CITY OF ALBUQUERQUE

**RE: Oakland Heights Subdivision (File: C19D063)
Grading and Drainage Plan, Engineer's Date 2-24-16**

**RE: Oakland Heights Subdivision (File: C19D063)
Grading and Drainage Plan, Engineer's Date 12-1-15**

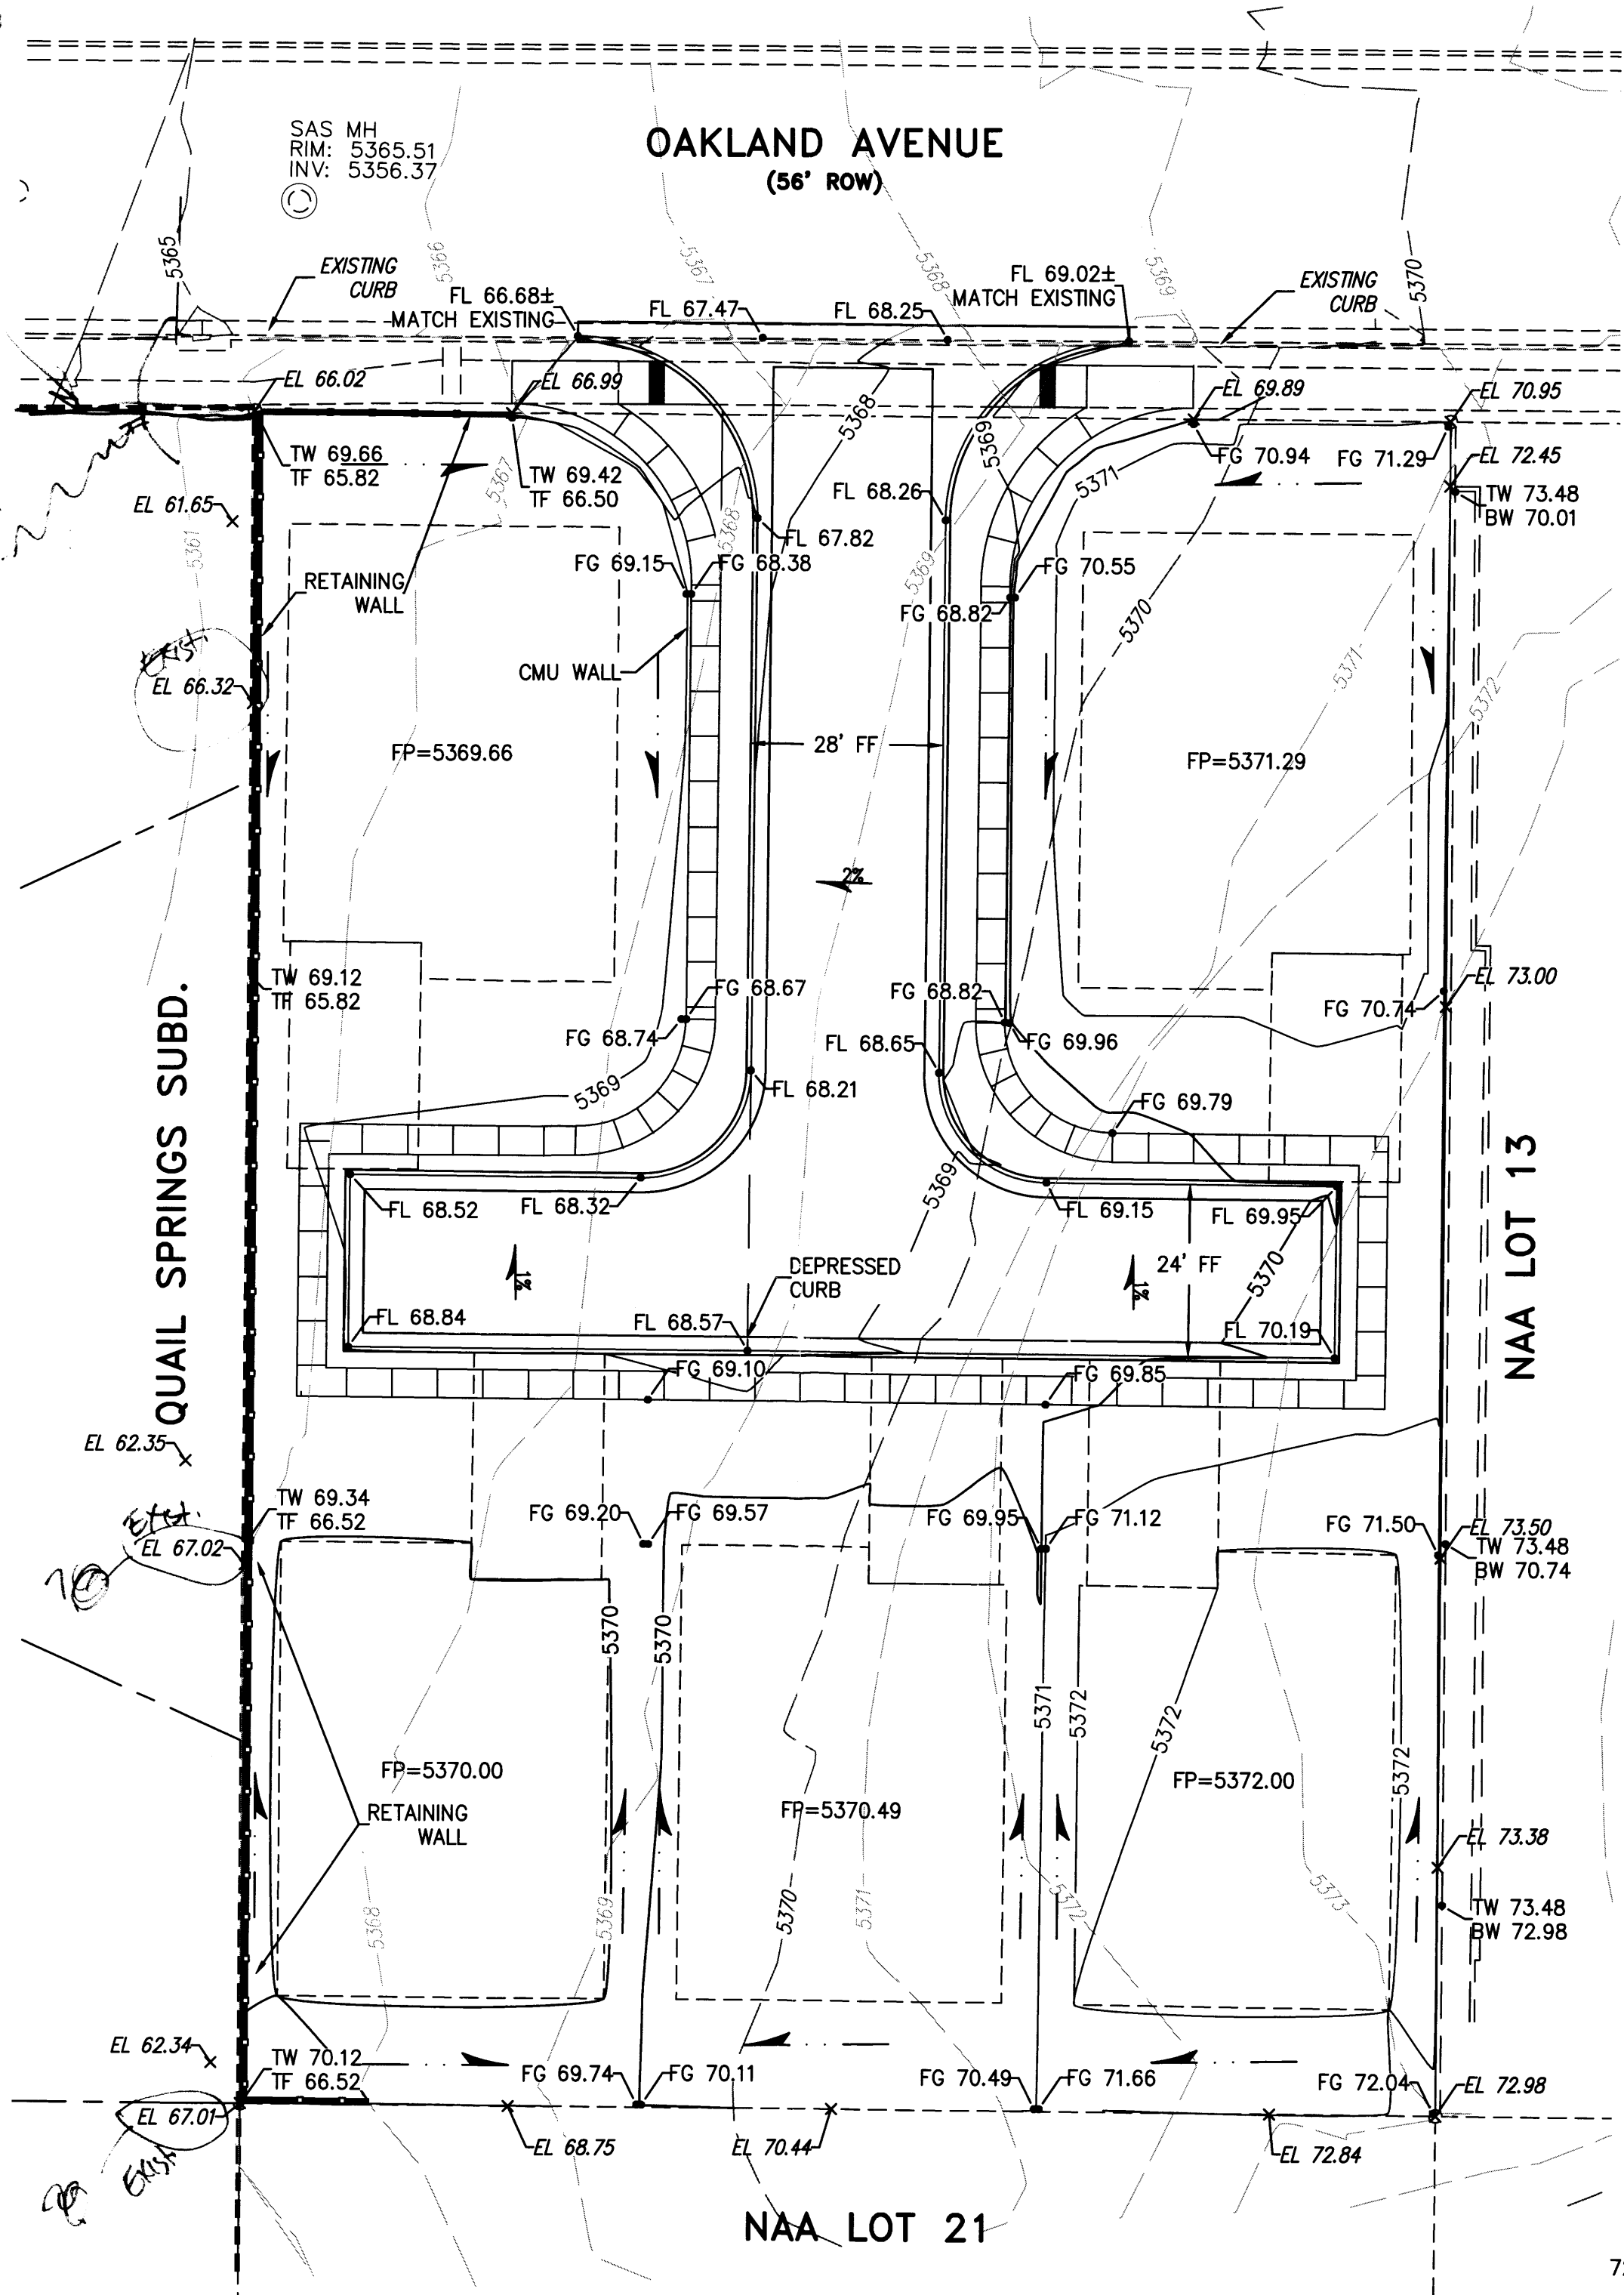
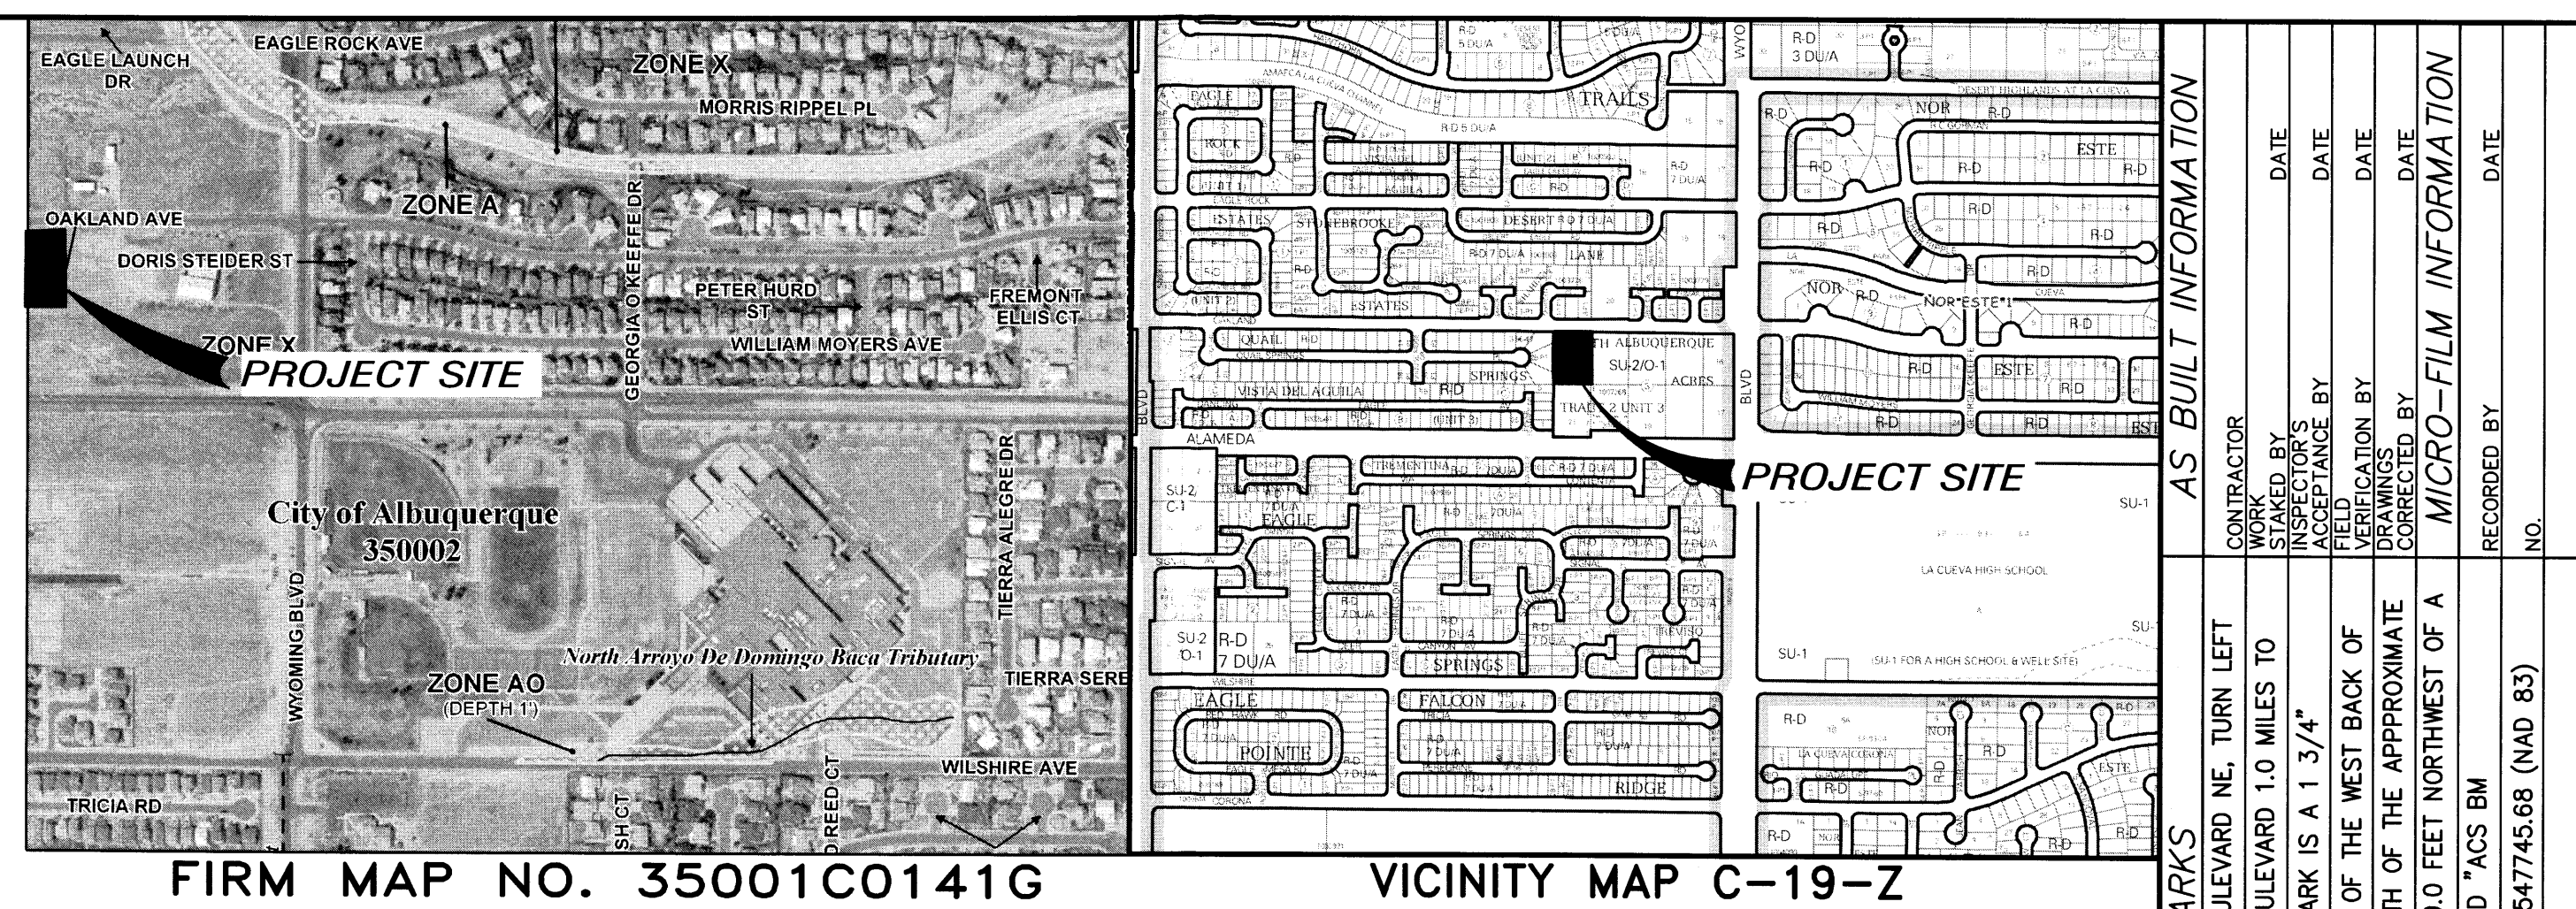
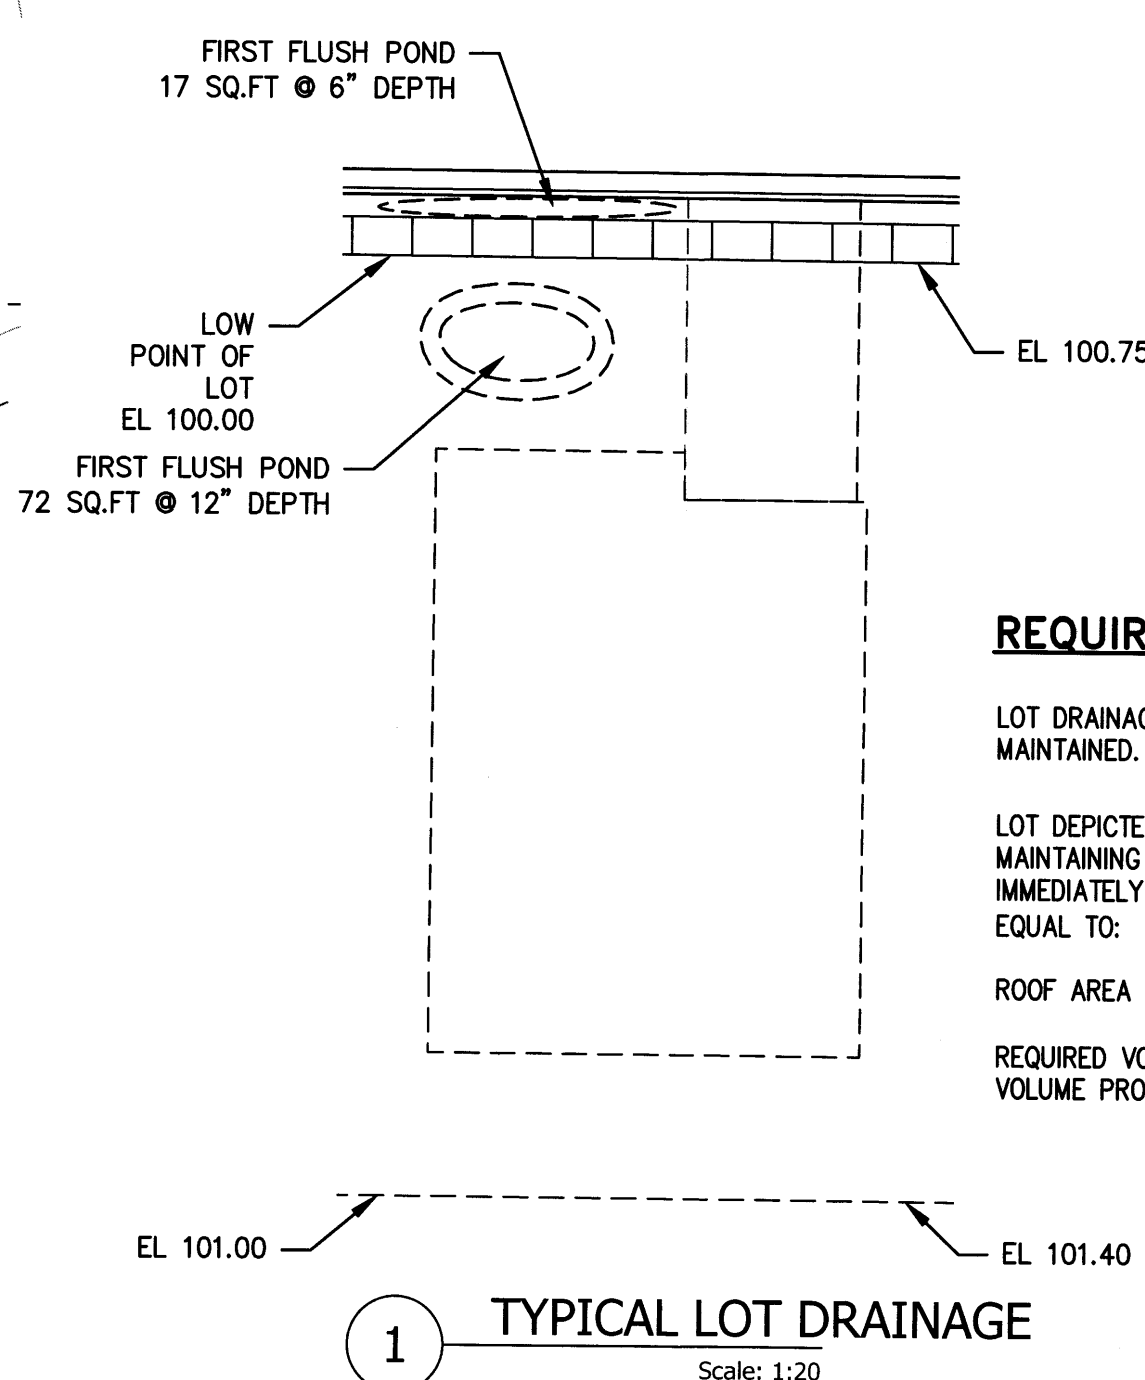
1. Looking at the NAAMDP Appendix, the Land treatments for this sub-basin are 25%B, 15% C, and 50% D (not 60% D as implied in the Land Treatment , Fig. 2A). Revise the Table to reflect these numbers, also state the Basin # that this site is in.
2. Provide existing contours or existing spot elevations for the site west of this development.
3. The East property line will have an existing retaining wall at the time of construction. Show the TW/BW elevations and indicate that it is a retaining wall currently under construction per drainage report C19D062.
4. Indicate in the Narrative why this site does not accept offsite flows.

1. The land treatments and runoff for existing condition were changed.
2. Elevations adjacent to the site have been included.
3. The elevations for the wall east of site have been included.
4. Narrative was modified.
